From: Nicola Spencer
Sent: 09 June 2026 15:40
To: [REDACTED]
Subject: RE: Request for further information EP/56/26/L

Vista Point BN16 2TE
Your Reference: **EP/56/26/L** and **EP/55/26/HH**

We have received letters noting that the applications for planning and listed building consent are invalid. I would contest that these letters may have been issued in error, at least in part. Please see points below. Your queries in italics, my responses in blue.

DRAWING No.
2105 3EX01

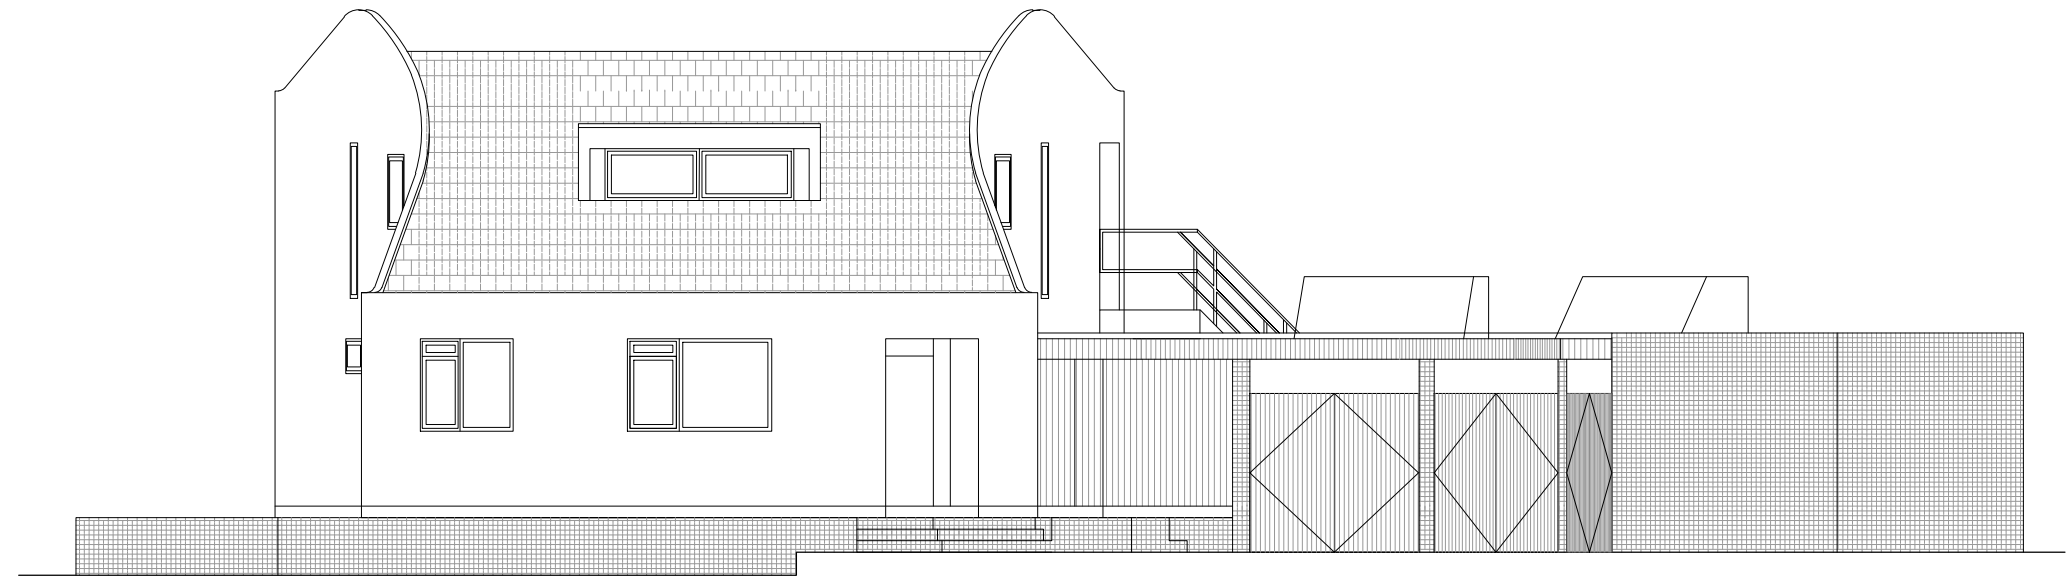
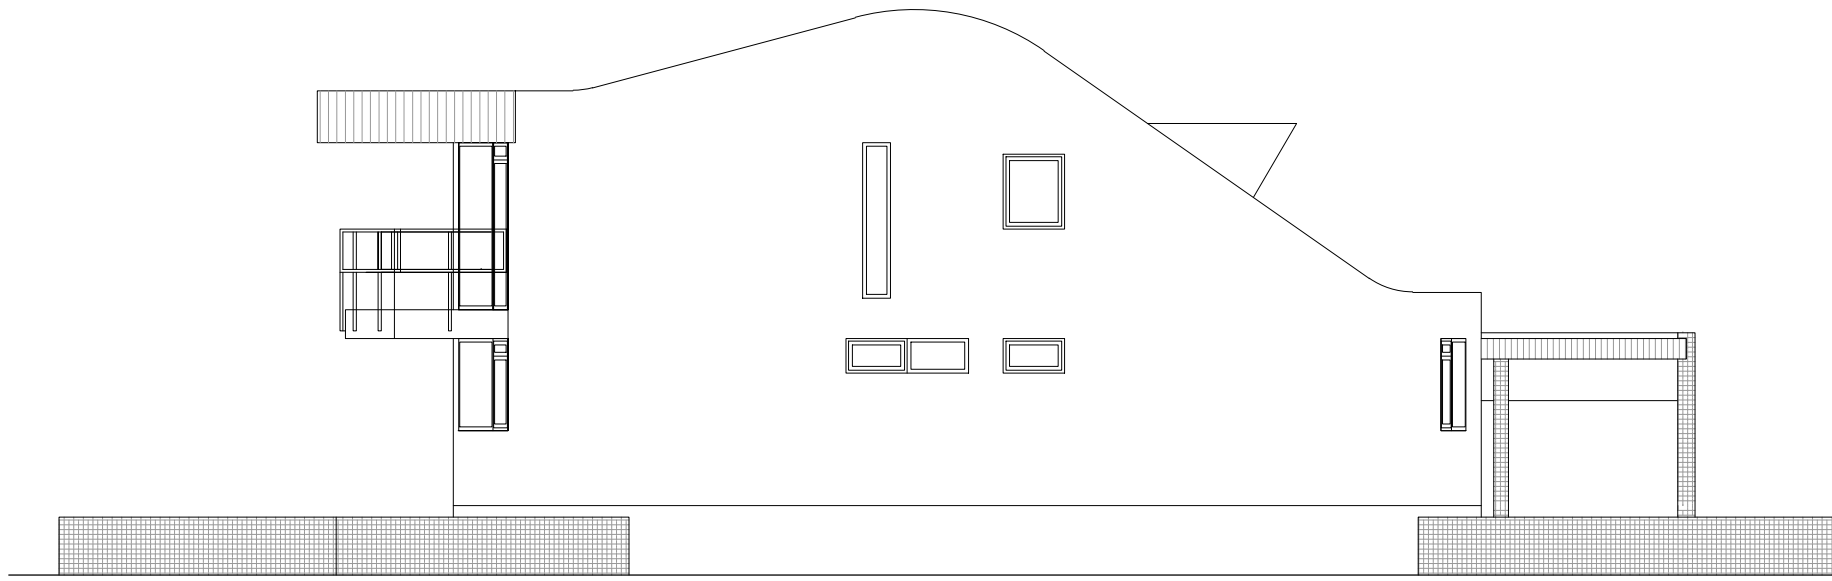
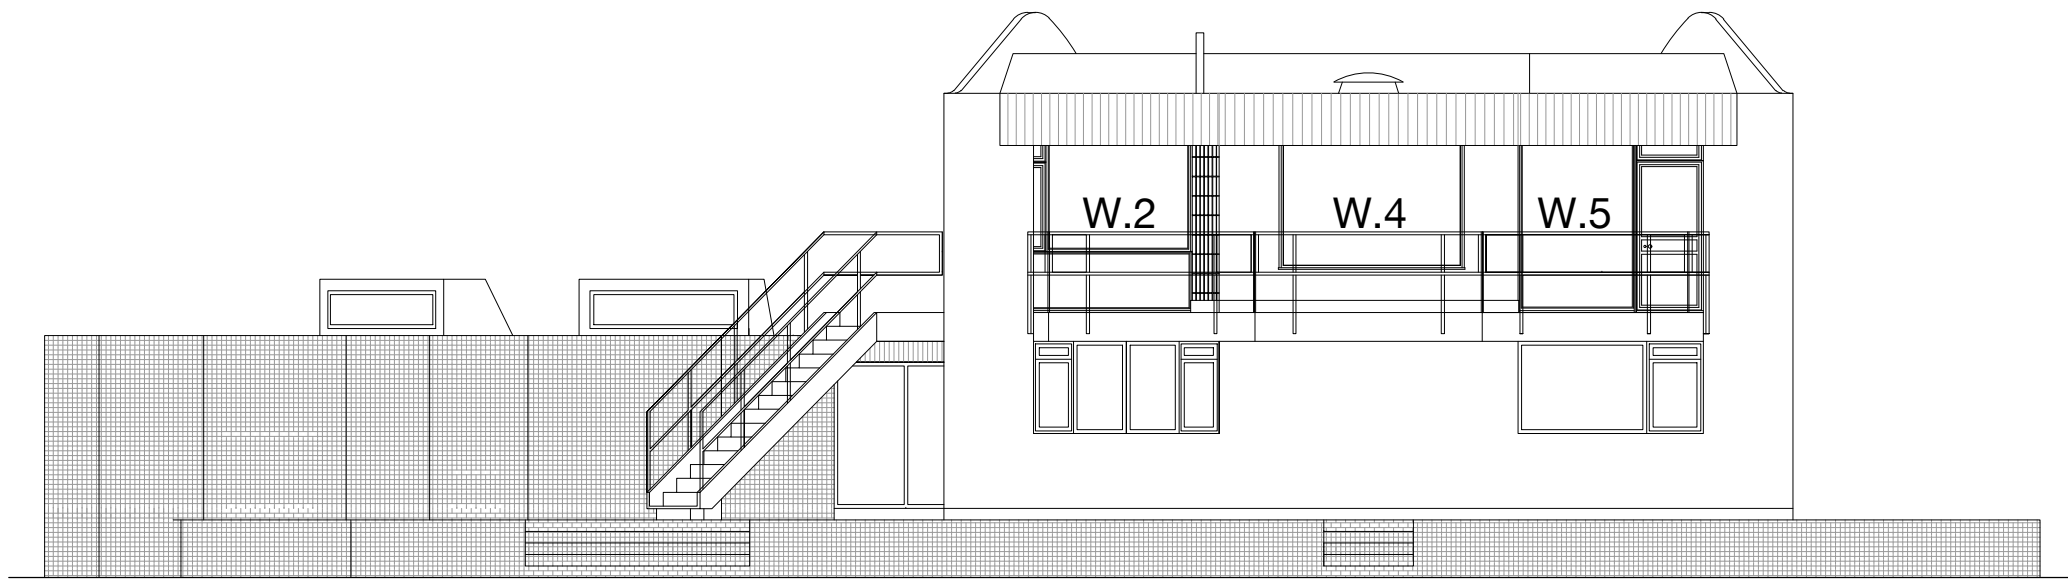
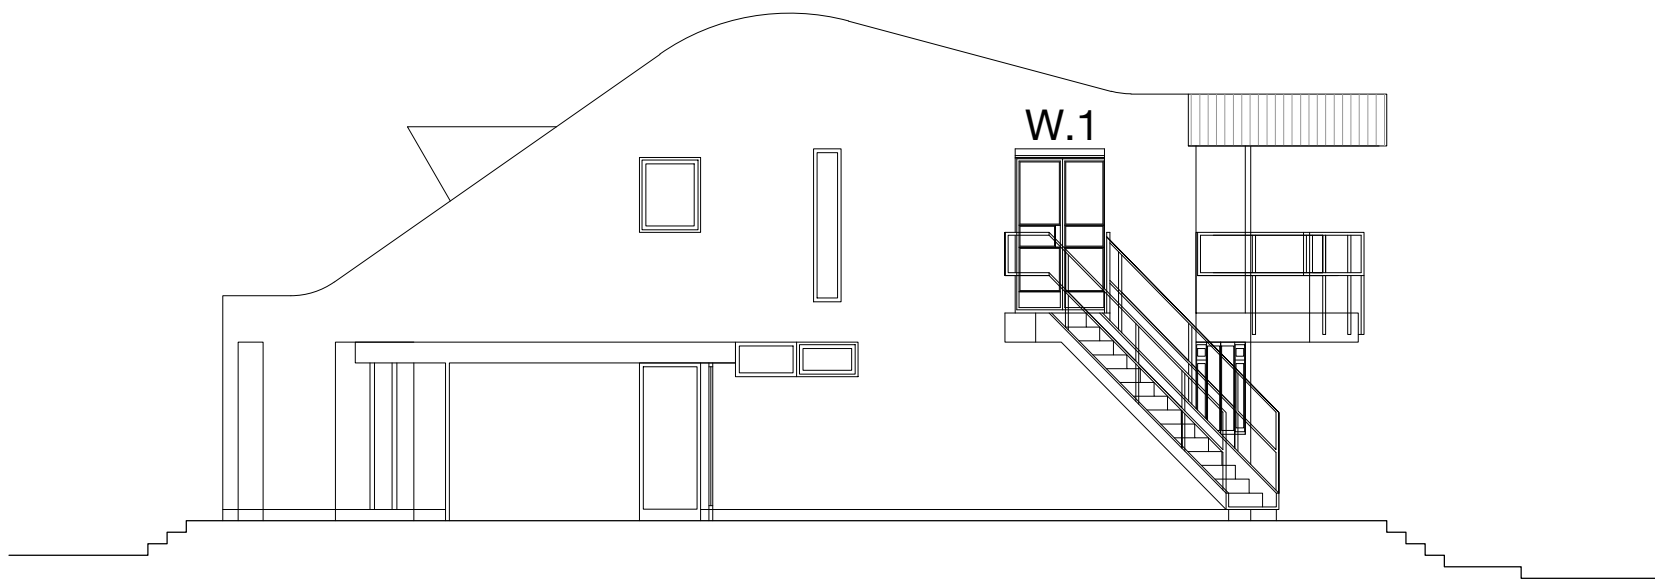
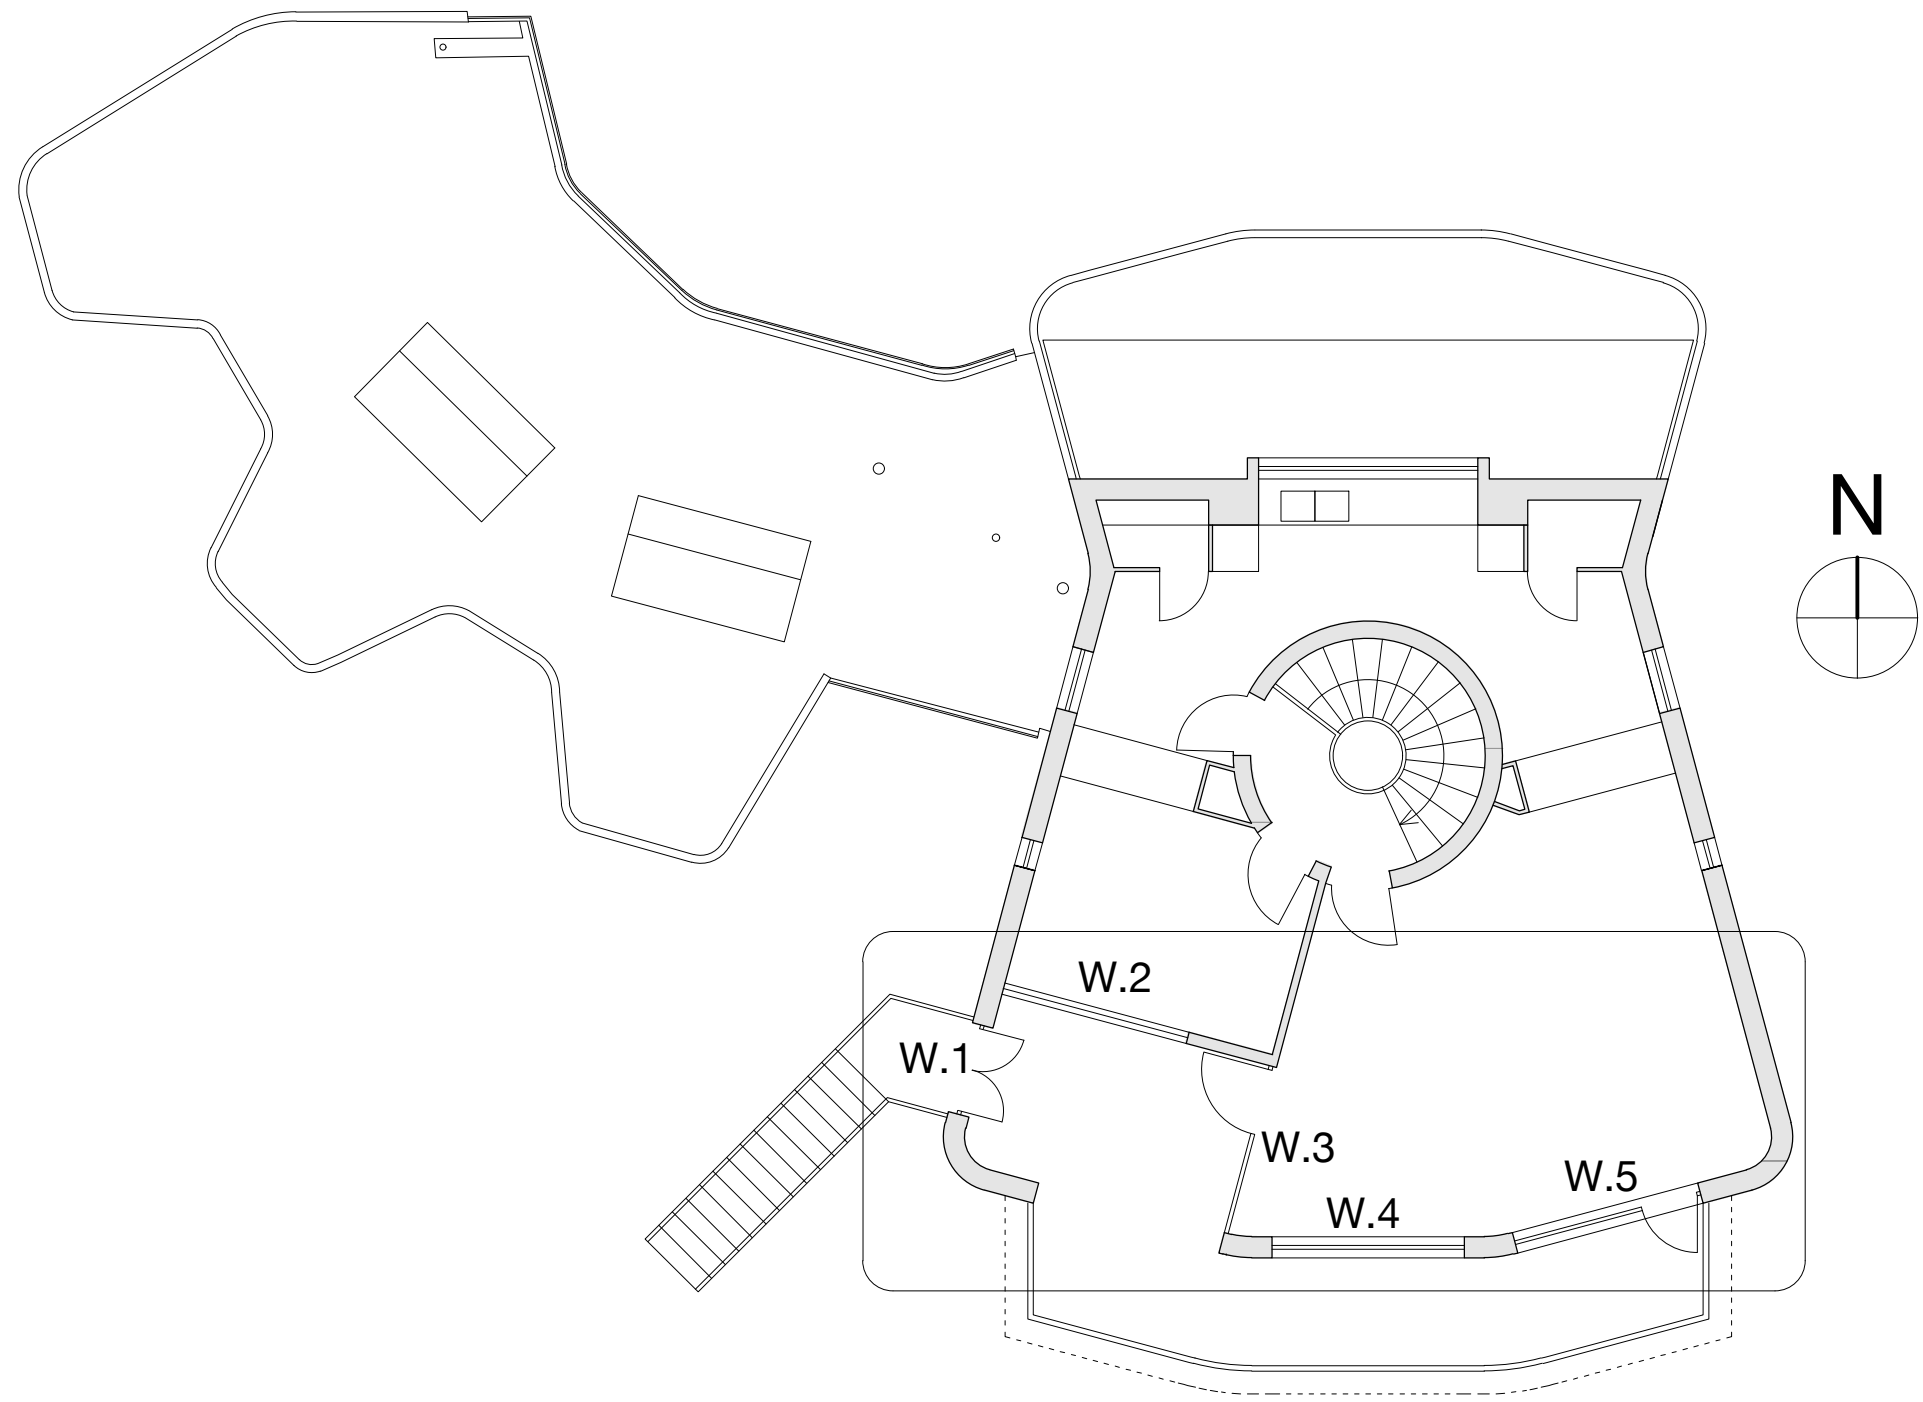
My colleague has referred this matter to me. Your plans do not scale for us as I think they have been scanned in as fit to page. They should be scanned in at no scale so that they can be electronically measured. If you do not want to rescan them so that we and the public can measure them electronically, you will need to provide us with a complete paper set that scales so that we can arrange for them to be scanned in. We deal with plans from agents, on a daily basis and there is no problem at our end, it is the way your plans have been formatted/scanned.

I have now had a colleague independently review the plans, and we are both in agreement that they are not scaling at 1:100. Within the programme we use, the paper size does not affect scaling, and we have verified this against other A1 drawings which are measuring correctly.

The scale bars on the proposed and existing elevation plans do not scale at 1:100. Existing and proposed elevations should either be 1:50 or 1:100."

- A sheet of A1 paper measure 841mm wide by 594mm high
- When printed at A1 the 1:100 scale bar noted at 20m long measures exactly 200mm long which is correct. (100x less than 20m).
- Please see attached

I have checked myself and the drawings do scale at 1:100 @A1 as noted.
